From: [REDACTED]
Sent: 29 June 2026 08:21
To: Planning
Subject: Planning Application 3/2026/0354

I strongly object to planning application 3/2026/0354.

The proposed two-storey side extension would cause clear and unacceptable harm to neighbouring residential amenity, directly conflicting with Policy DMG1 of the Ribble Valley Local Plan and paragraph 135 of the NPPF (2023).

Notes
This drawing is the property of IDC Home Architecture Ltd and copyright is reserved by them. This drawing is not to be copied or disclosed by or to any unauthorised persons without the prior written consent of IDC Home Architecture Ltd.

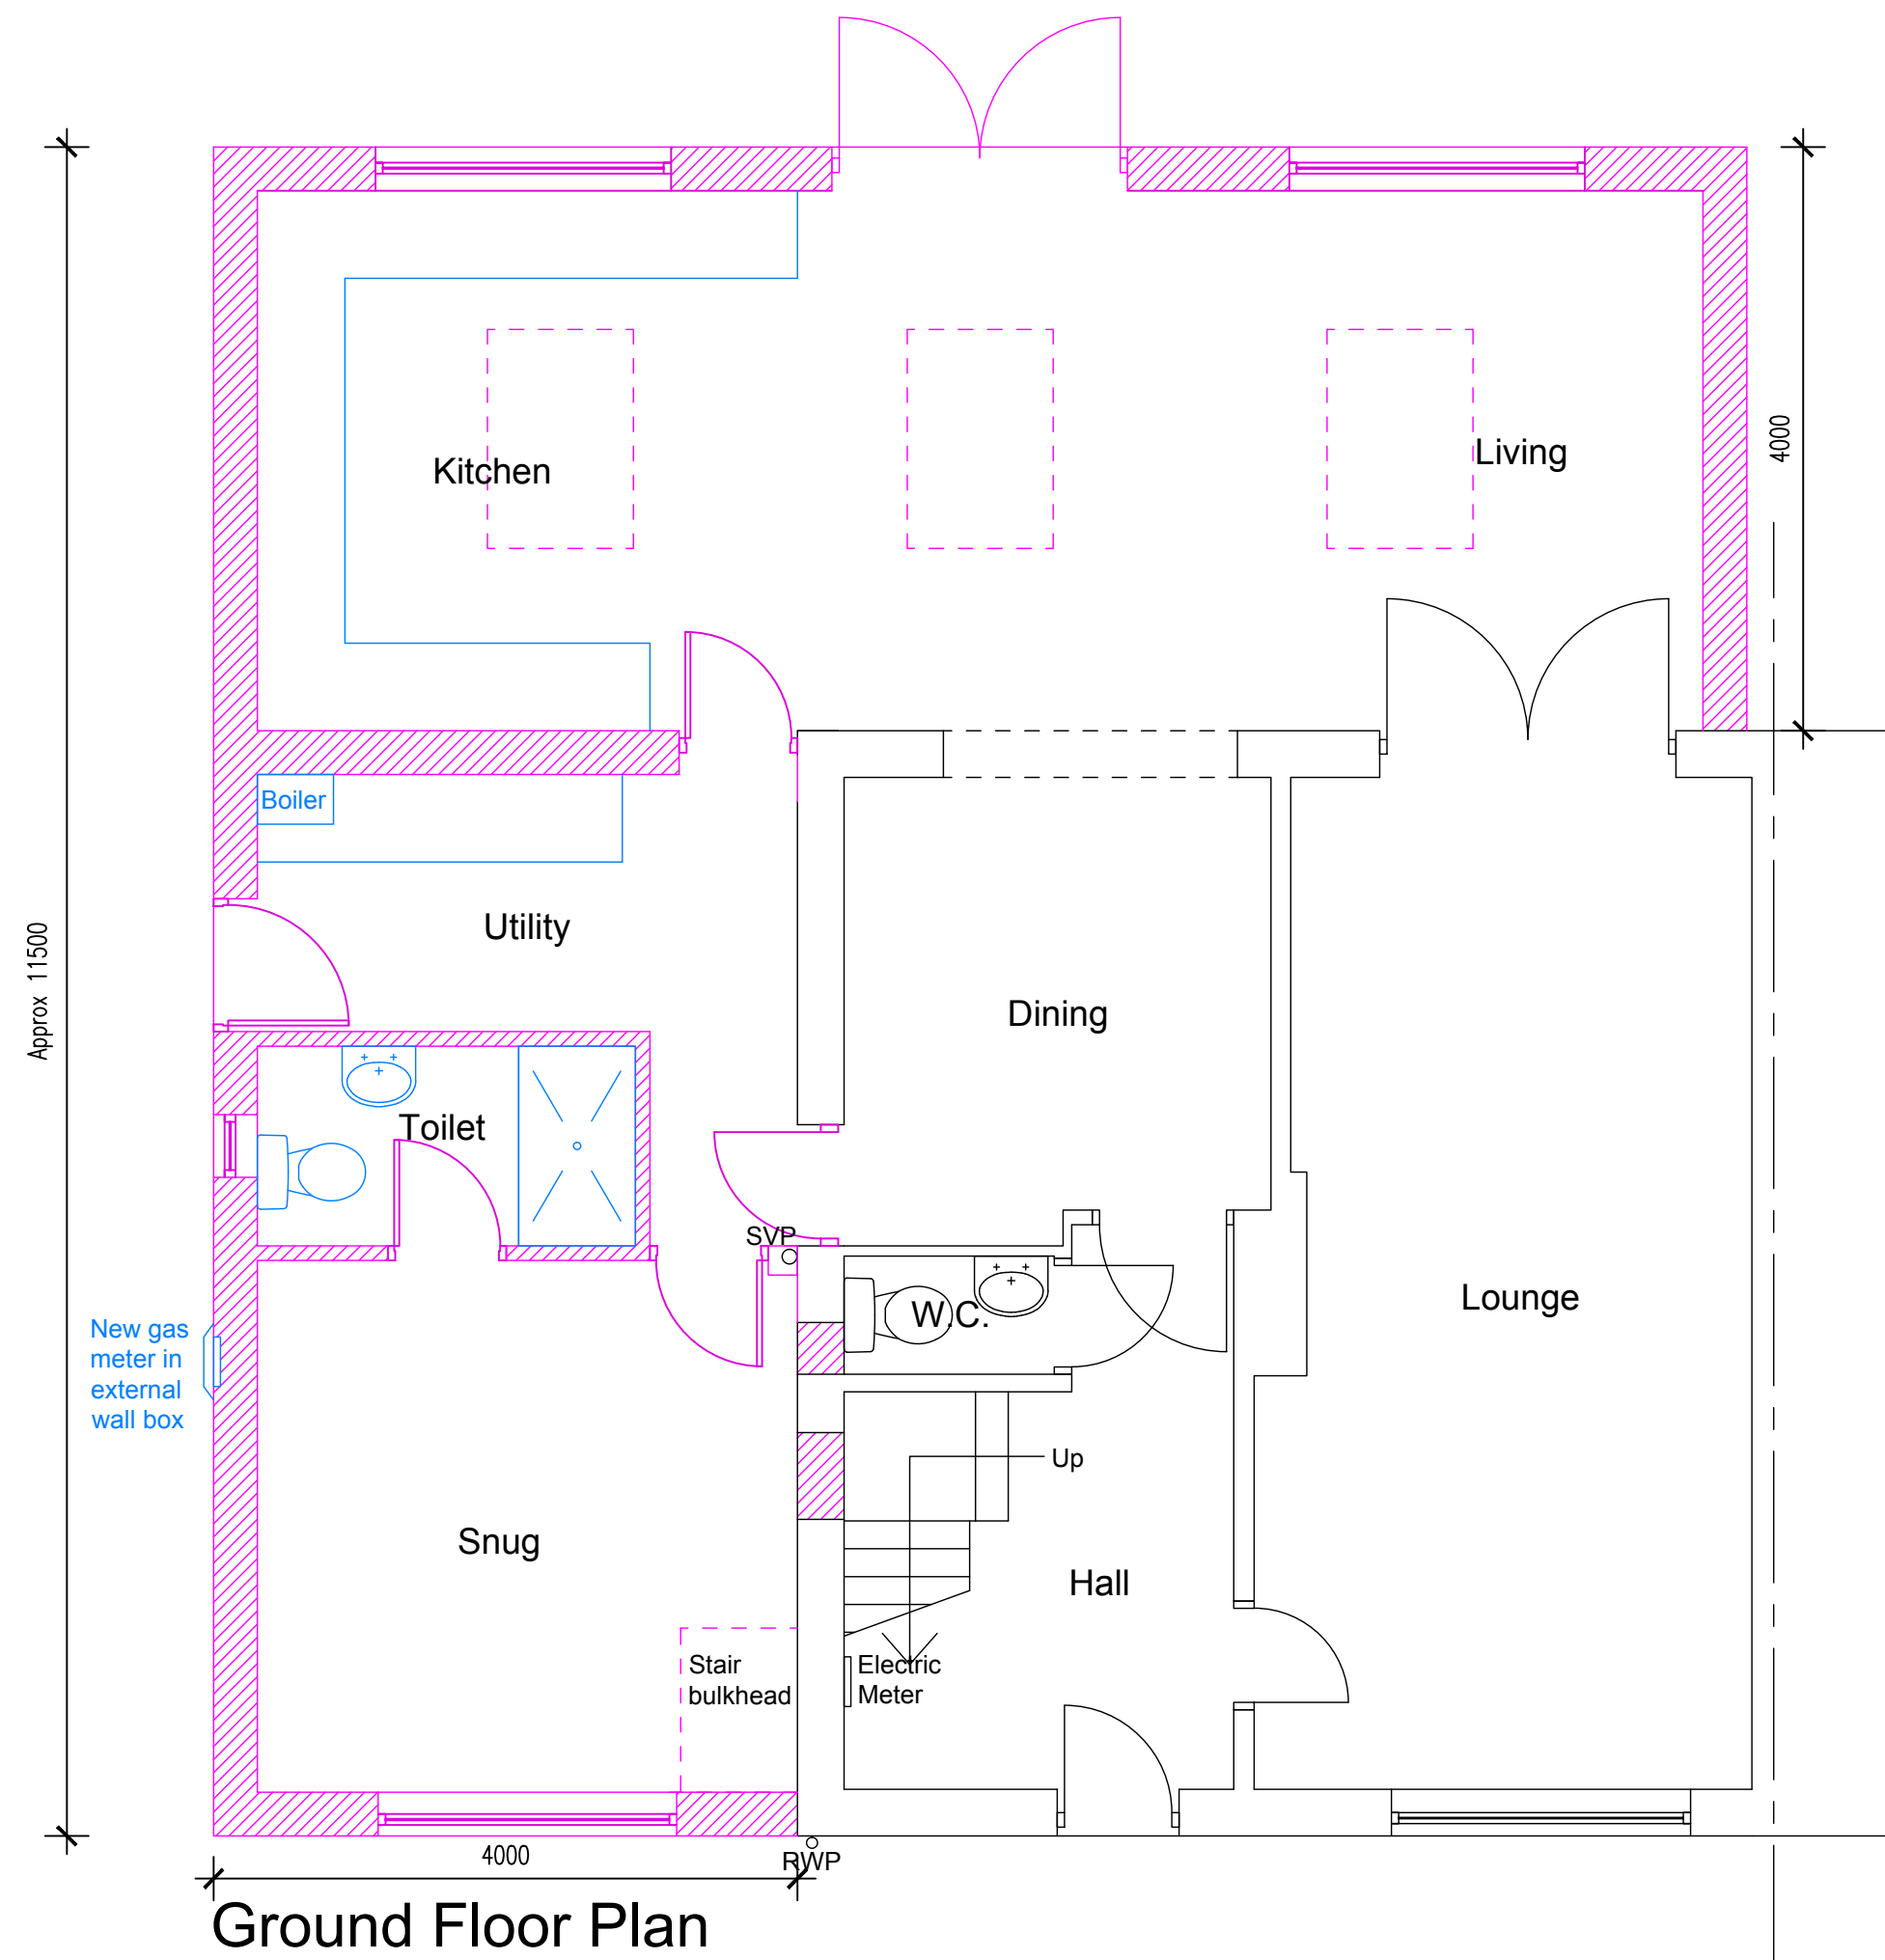
Most significantly, the inclusion of large first-floor side-facing windows is wholly unjustified and unacceptable. These openings, even if obscure-glazed, would directly face neighbouring private garden spaces and introduce an intrusive and overbearing element. Their excessive size further exacerbates this issue and creates an unnecessary and avoidable risk of overlooking.

Secondly the use of full height windows to side elevation seems both intrusive to the adjacent dwelling and also unnecessary in respect that the other extended accommodation on the similar houses have no glazed windows whatsoever to the side elevation. Also seems preposterous to have an unfrosted window in what is to be an ensuite bathroom at the front of the proposed extension.

In addition to these points using the boundaries highlighted in the location plan, given scales and the existing dimensions alongside the proposed dimensions it appears the proposed extension at an overall width of 10.5M is to be either on or extremely close to the boundary of the adjacent property. This would therefore create a both dominant and intrusive structure, not to mention the lack of access to maintain or construct the extension in the first instance. Its my understanding that in accordance with the access to neighbouring land act 1992 any access required for scaffolding, construction or future maintenance such as soffits, guttering or rendering would need to be sought from the occupiers of the adjacent property and that would be categorically denied.
